PROJECT	DATE	BY	REFERENCE
5015416 – Pagham Phase 3 Reserved Matters – Planning	09 Feb 2022	TC	5015416 - TN-0001

Response To Drainage Officer

Ridge and Partners prepared a Drainage Strategy to accompany a planning application for Pagham Phase 3. This document looks to provide a technical response to the comments received from the Drainage Engineer working for Arun and Adur Councils.

Proposed Soft Landscape Sheet 1 of 3

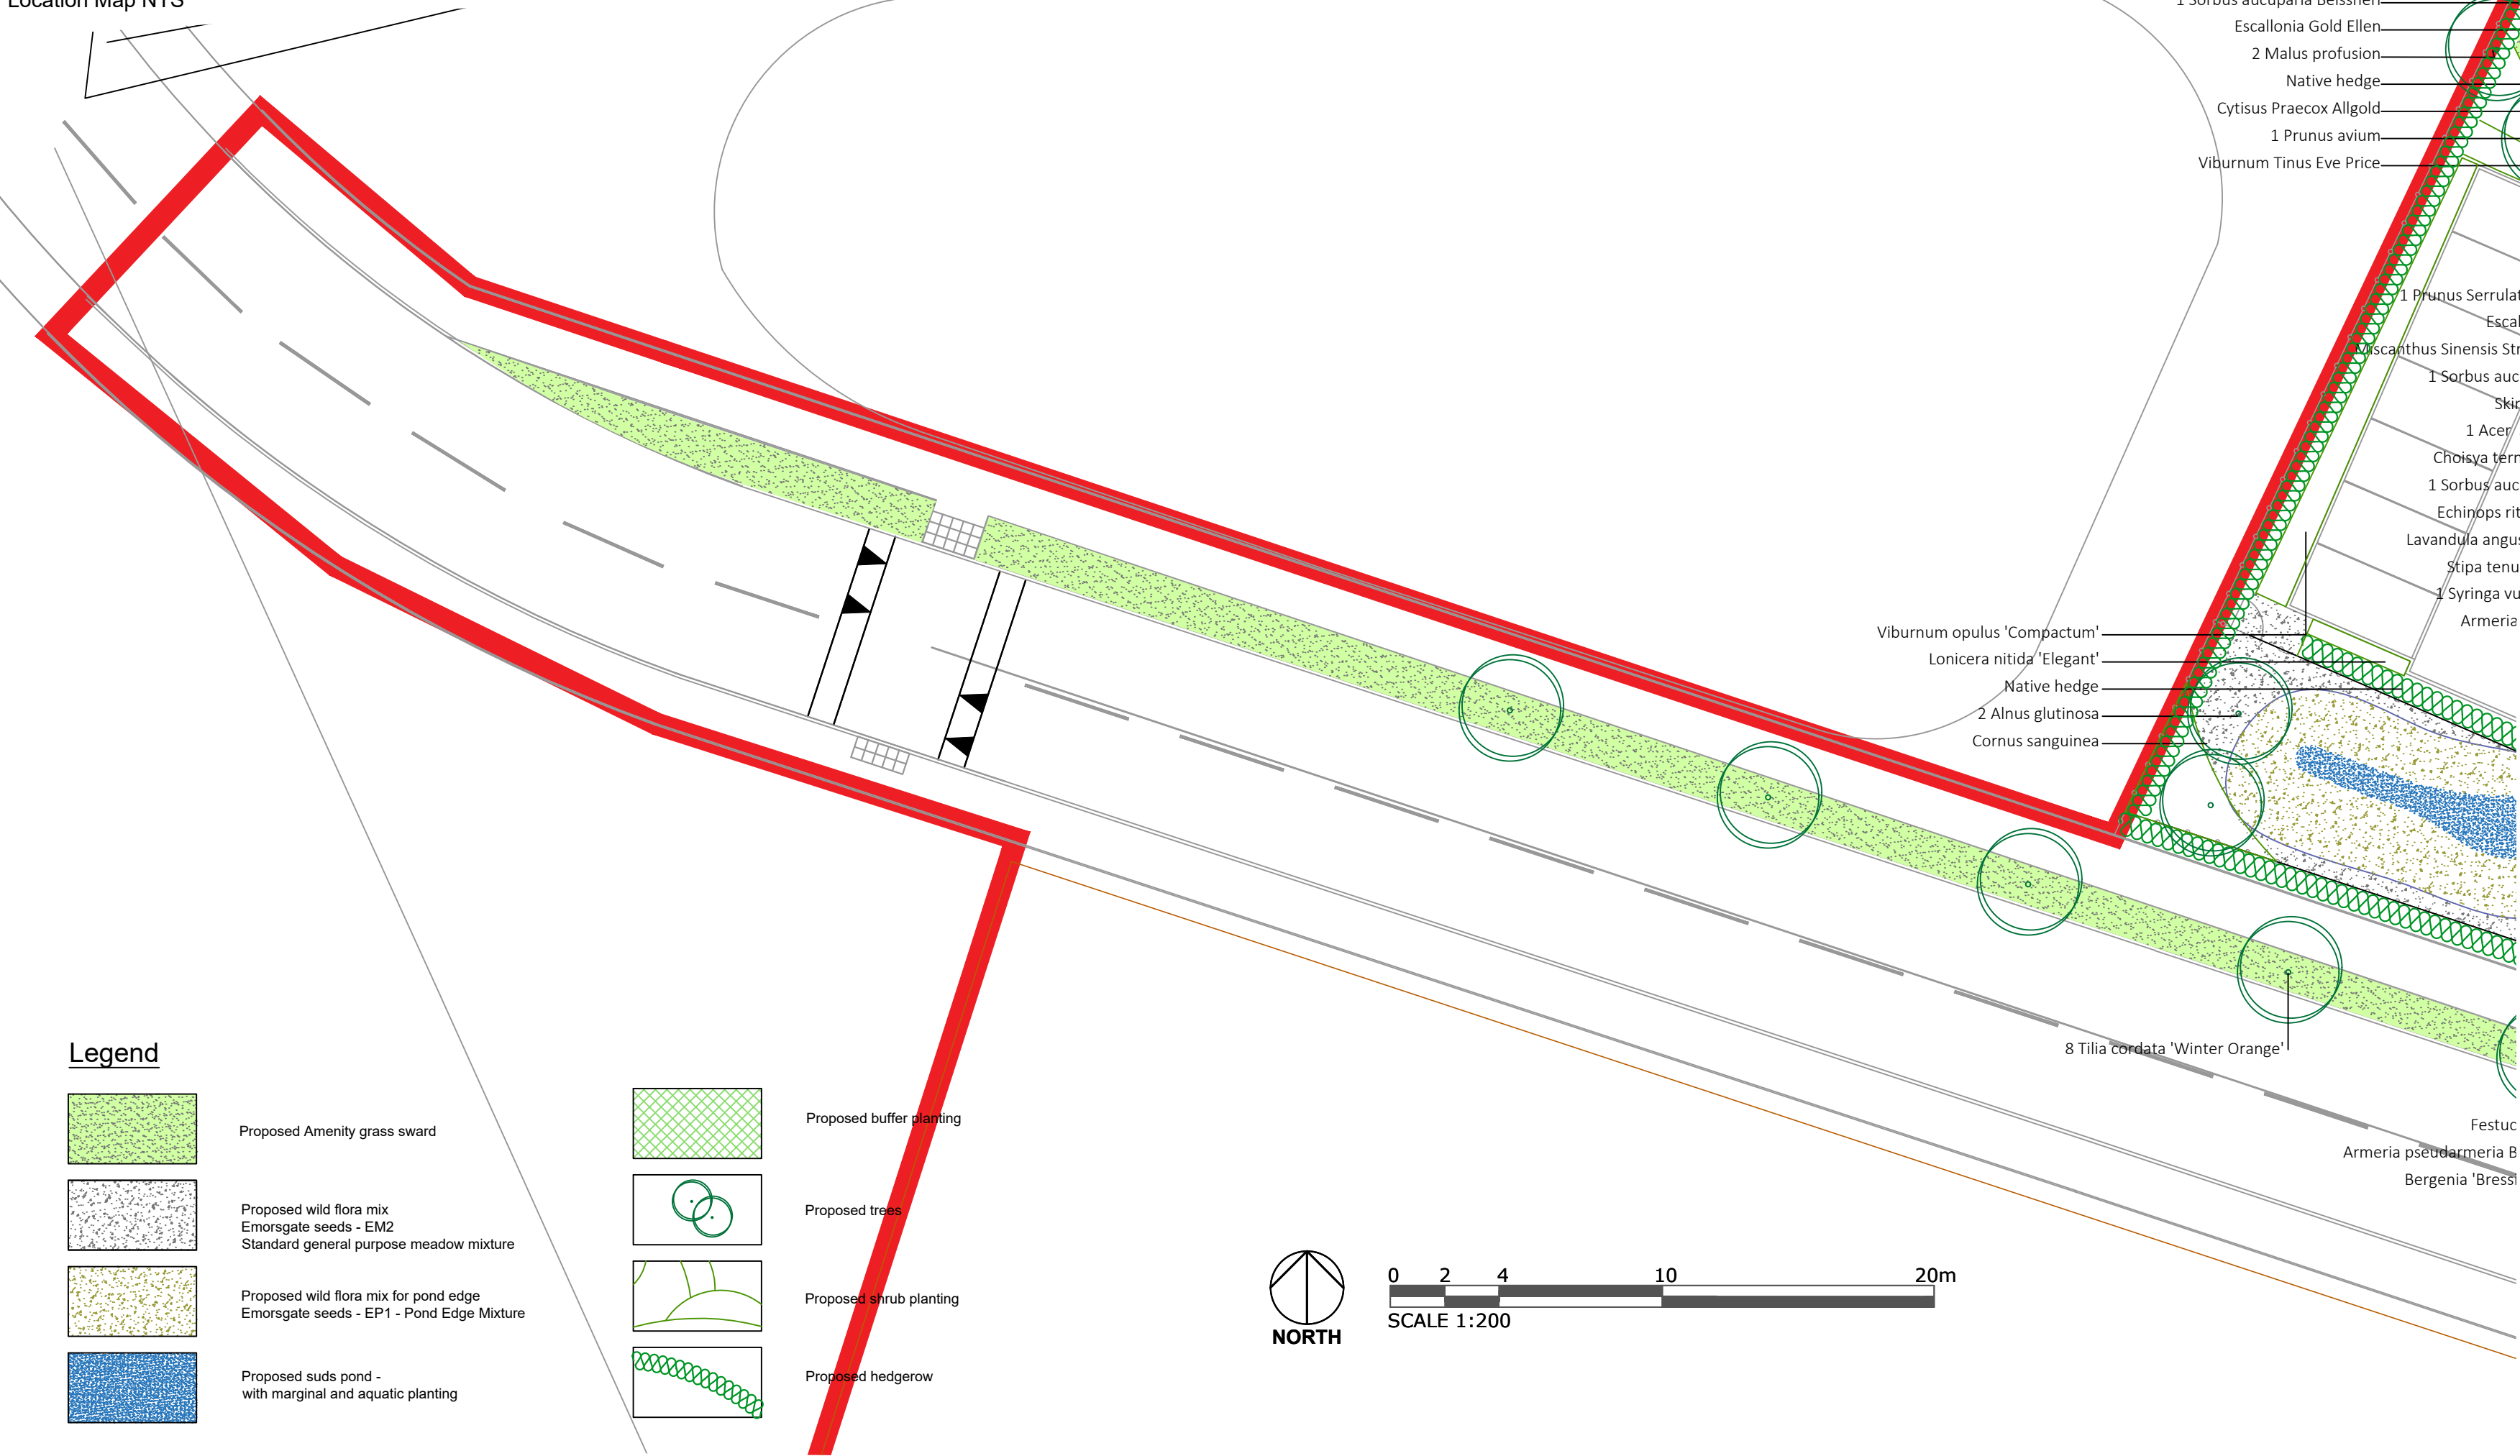
We note that a number of trees are proposed in close proximity to drainage features. Root potential areas must not conflict with surface water drainage features.

Trees, vegetation and planting have been specified by the Landscape Architect and is shown on drawings 5068-DLA-L-02, 5068-DLA-L-03, and 5068-DLA-L-06 Proposed Soft Landscape Sheet 1 through 3. These have been specified to work in harmony with the proposed drainage features. Where necessary, trees will be designed to be enclosed within tree pits to ensure they does not affect the road make up or the geocellular tanks.

PROPOSED DRAINAGE STRATEGY

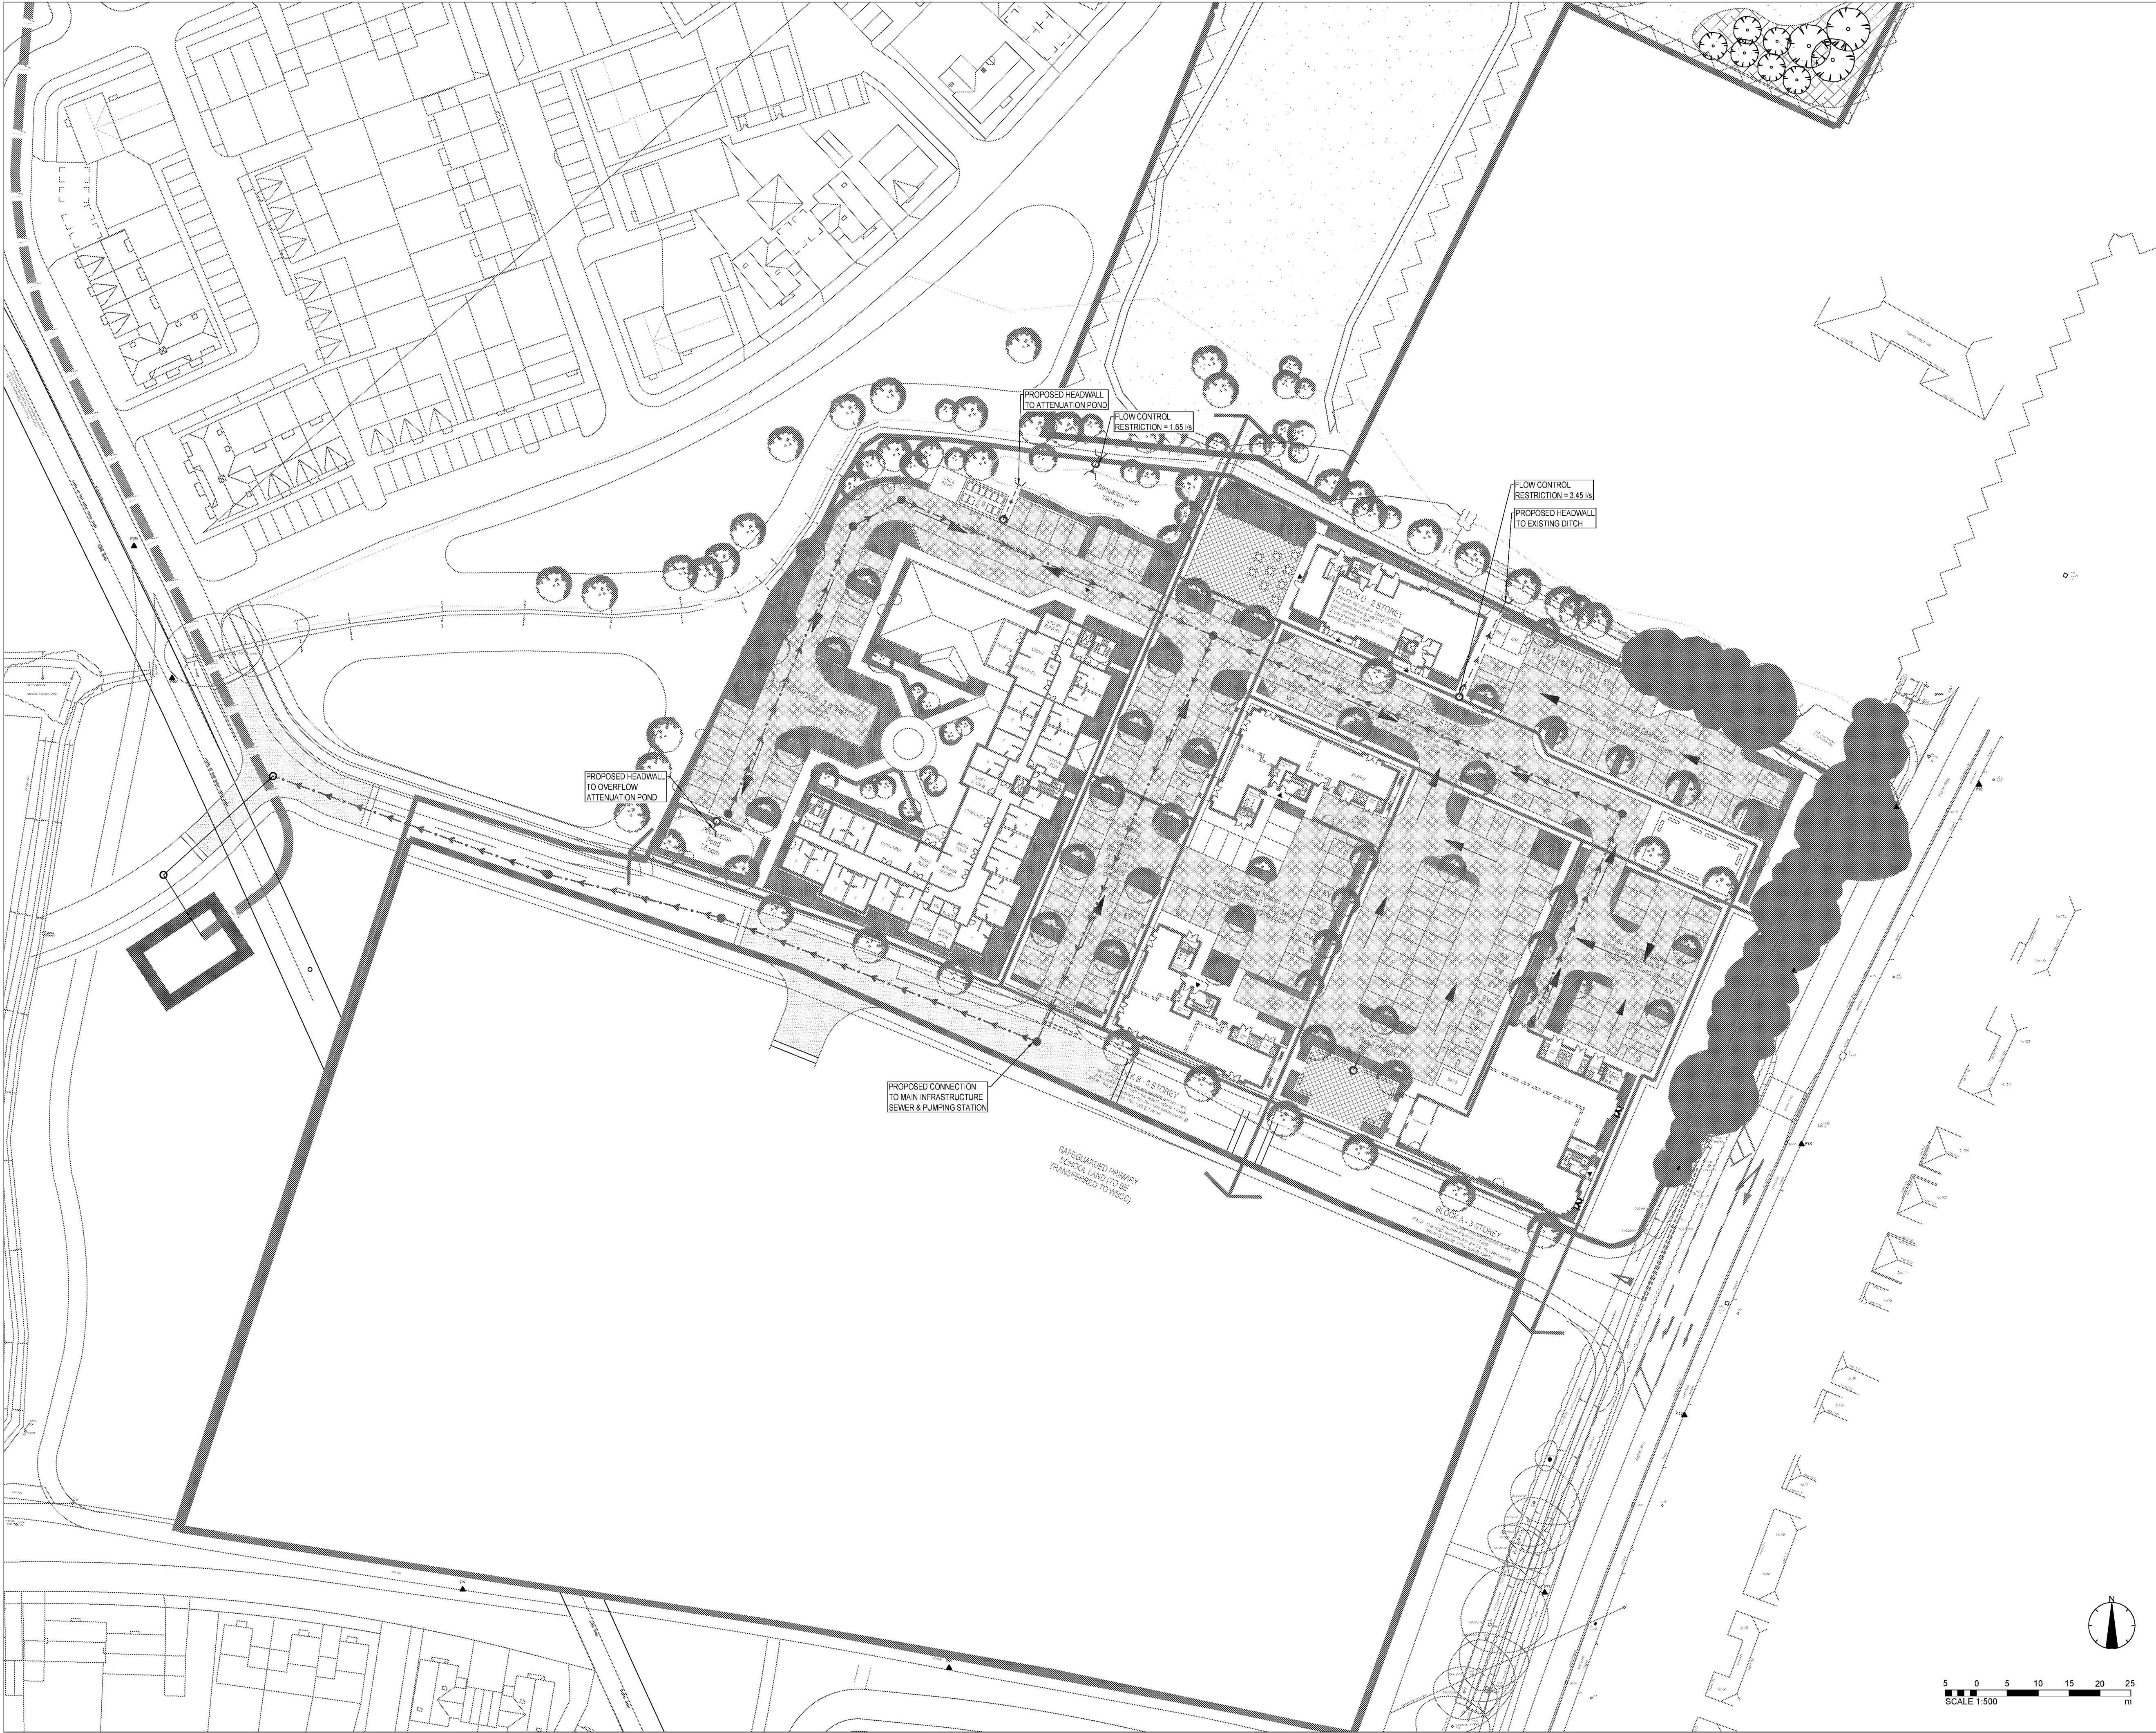
The proposed discharge rate is too high. The calculation of discharge rates should be based upon the positively drained area. Revised greenfield runoff rate calculations should be supplied.

A minimum of two perpendicular cross sections per basin must be supplied.

The overall site proposed discharged rate is set but the greenfield run off rate for the overall site area. As we are restricting all events to the QBAR greenfield run off rate this is industry accepted method. When sites are restricting to the greenfield run off rate for each storm event we would look to restrict to the positively drained area. The greenfield run off rate for the positively drained area of the site is 3.2l/s rather than the proposed 5.1l/s. This would increase the required volume of storage required during the extreme events across the site. However, as the calculations undertaken to date have been based on the worst case design parameters, from experience during detailed design the volumes required are greatly reduced. As the detailed drainage design is to be secured by condition 10, this information will be confirmed at that stage.

This detail will be provided as part of the information to discharge condition 10.
